From: Andrew Wood
Sent: 12 November 2018 13:23
To: Planning.Responses
Subject: FW: Condition 7 - FG/140/18/DOC - Landscaping Plan

FG/140/18/DOC - Landscaping Plan

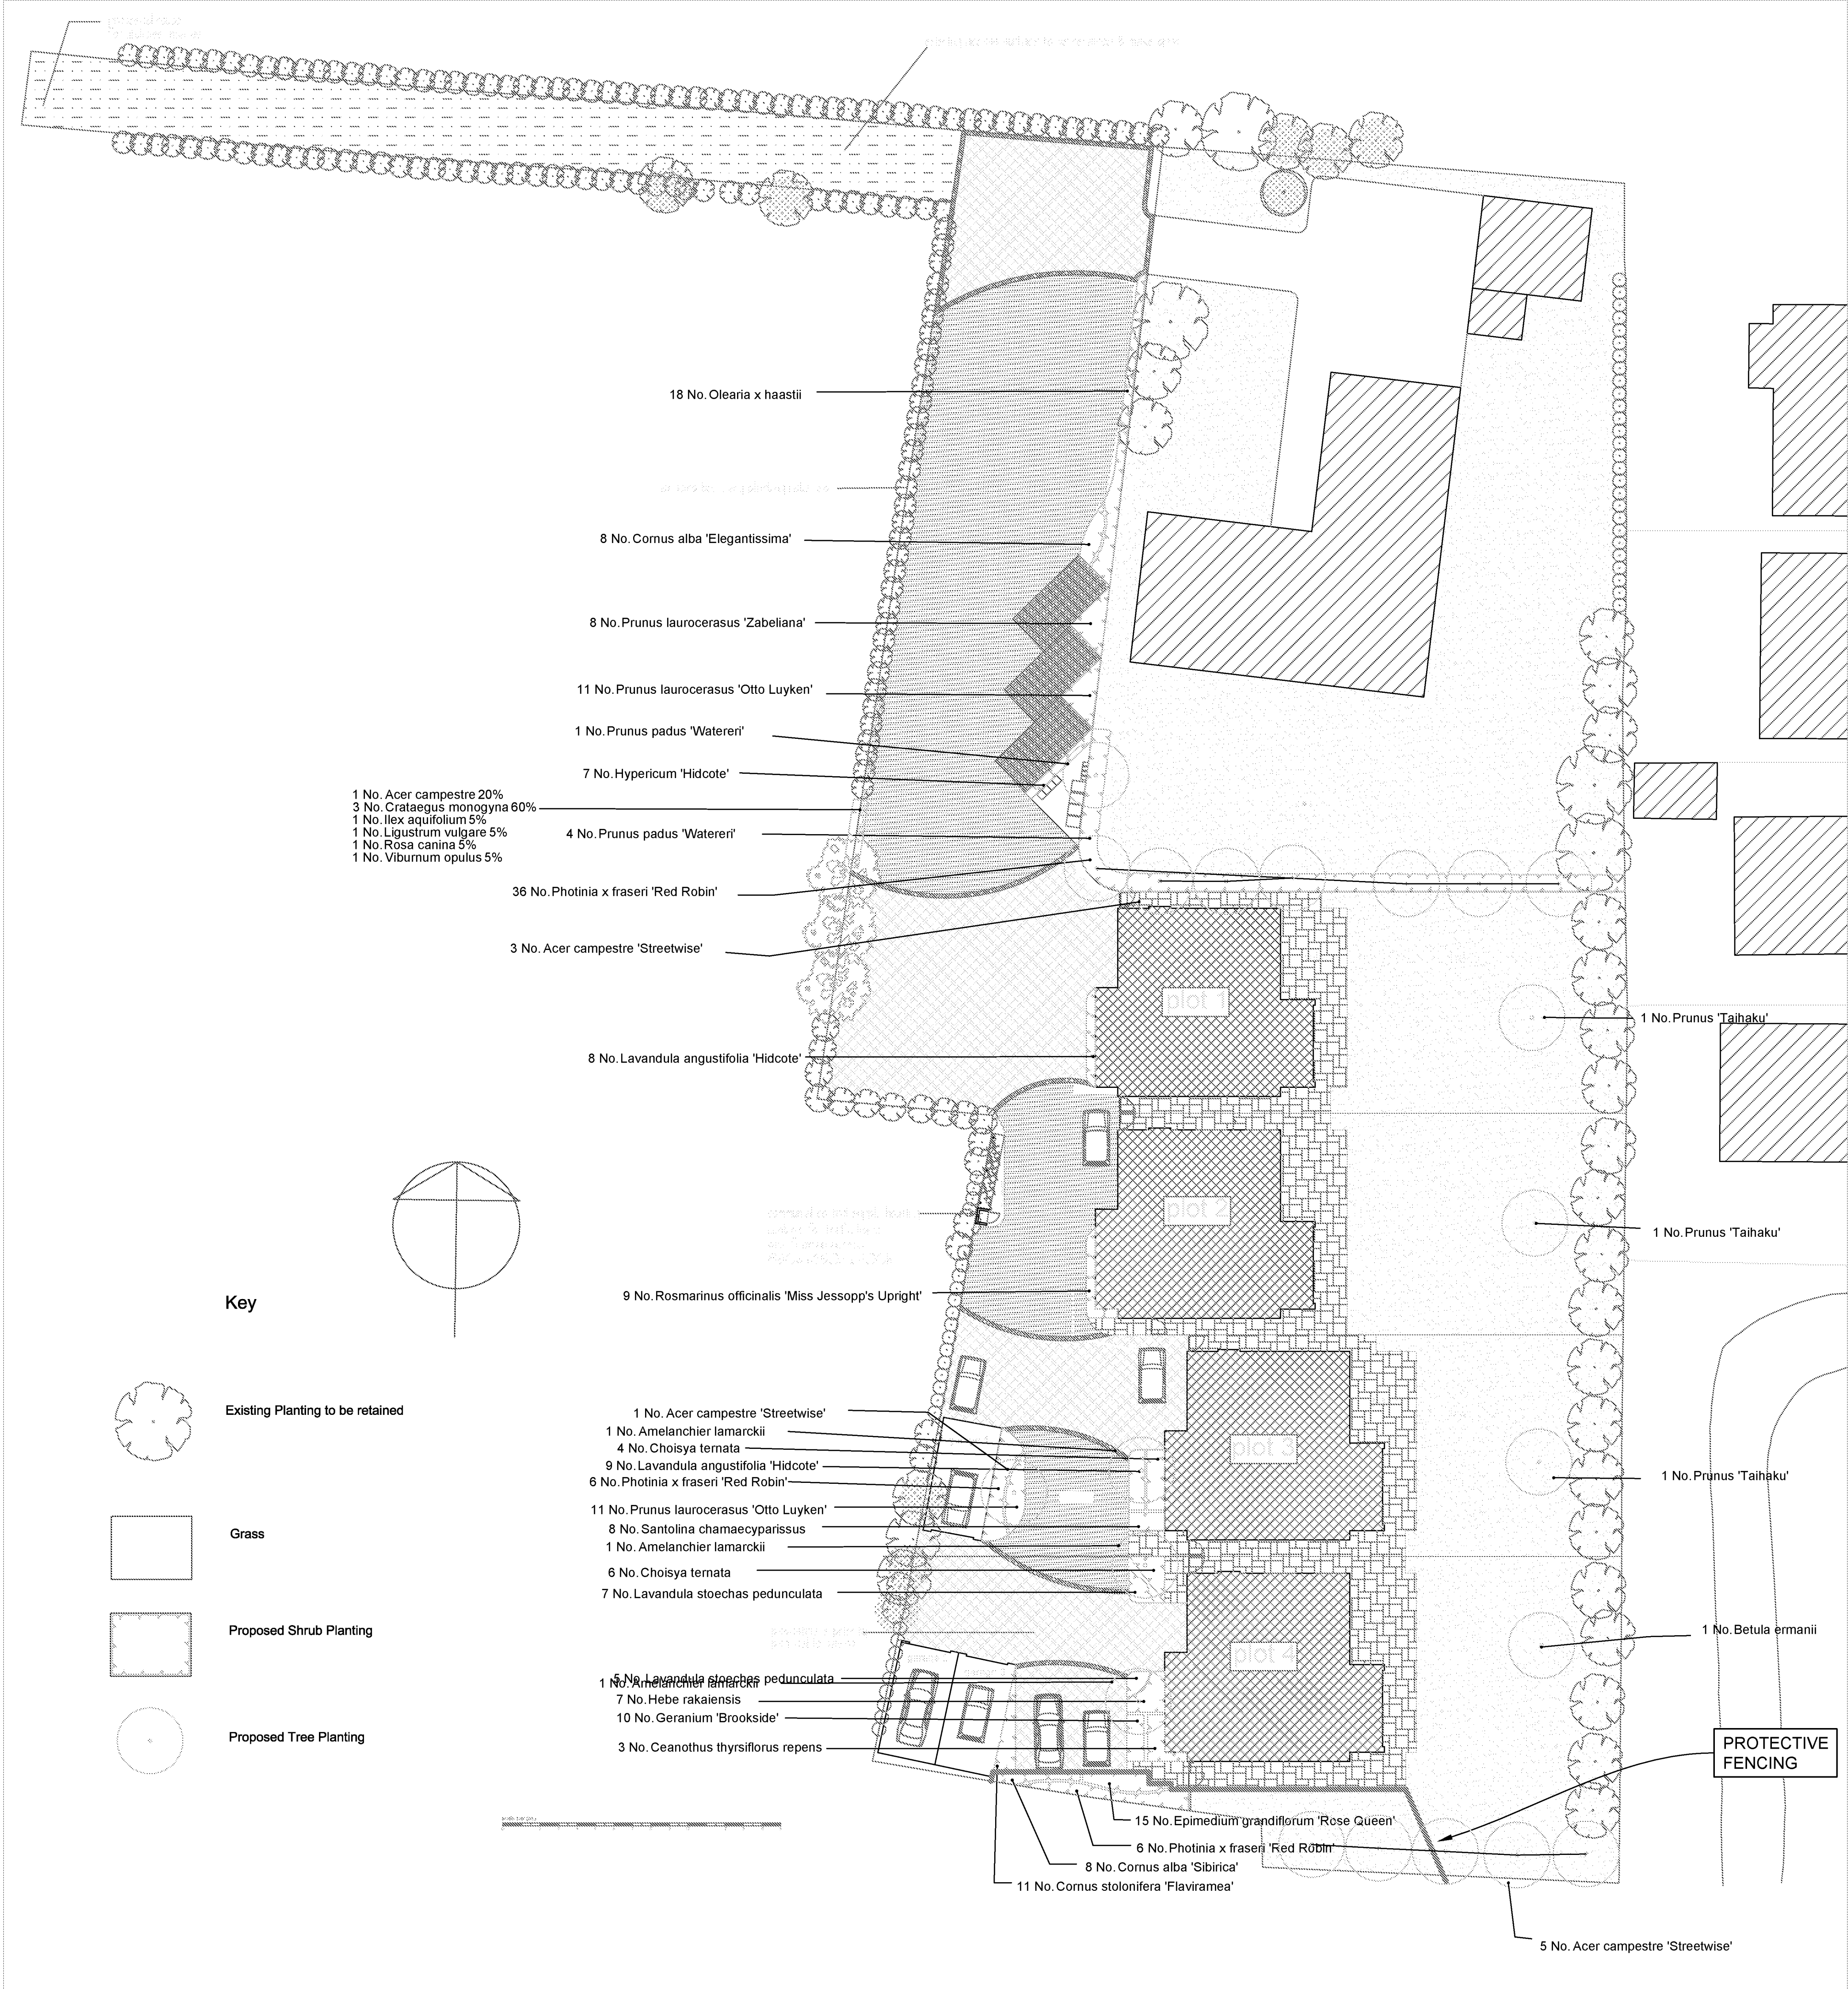
Could you please confirm by return of email that the leylandii and privet hedging along the eastern boundary of the site as indicated by the label 'existing boundary planting retained' on dwg.no. 731-L-01 Rev B is to be maintained at a height of 2 metres.

However, the plan on the portal does not show the 5 or so Leylandi planted just within 44 along the part of its western boundary privet hedge between myself at 42. All five trees are directly the otherside of my eastern boundary at 42.

Perhaps you could advise me of the applicants intention in relation to the height these LEYLANDI will be allowed to legally achieve, bearing in mind the proximity of their planting i.e. directly at the foot of the existing privet hedge that divides our two plots.

- 1) & 2) Noted – The hedging and trees shown are clearly outside the red line of the site boundary and have been assessed as such.
- 2) Noted - The 3 trees shown as existing on the western side of Mr. Salvidges plot as you rightly state are not part of the new build development and have not been considered as part of the approved landscaping plan.
- 3) The Leylandii have been indicated on the plan as 'retention of the existing planting'.

Please accept this email as confirmation that the leylandii and privet hedging along the eastern boundary of the site as indicated by the label 'existing boundary planting retained' on dwg.no. 731-L-01 Rev B will be maintained at a height of 2 metres.

Kindly accept this email that they will be trimmed down to maintain the height of the regular hedging plants.
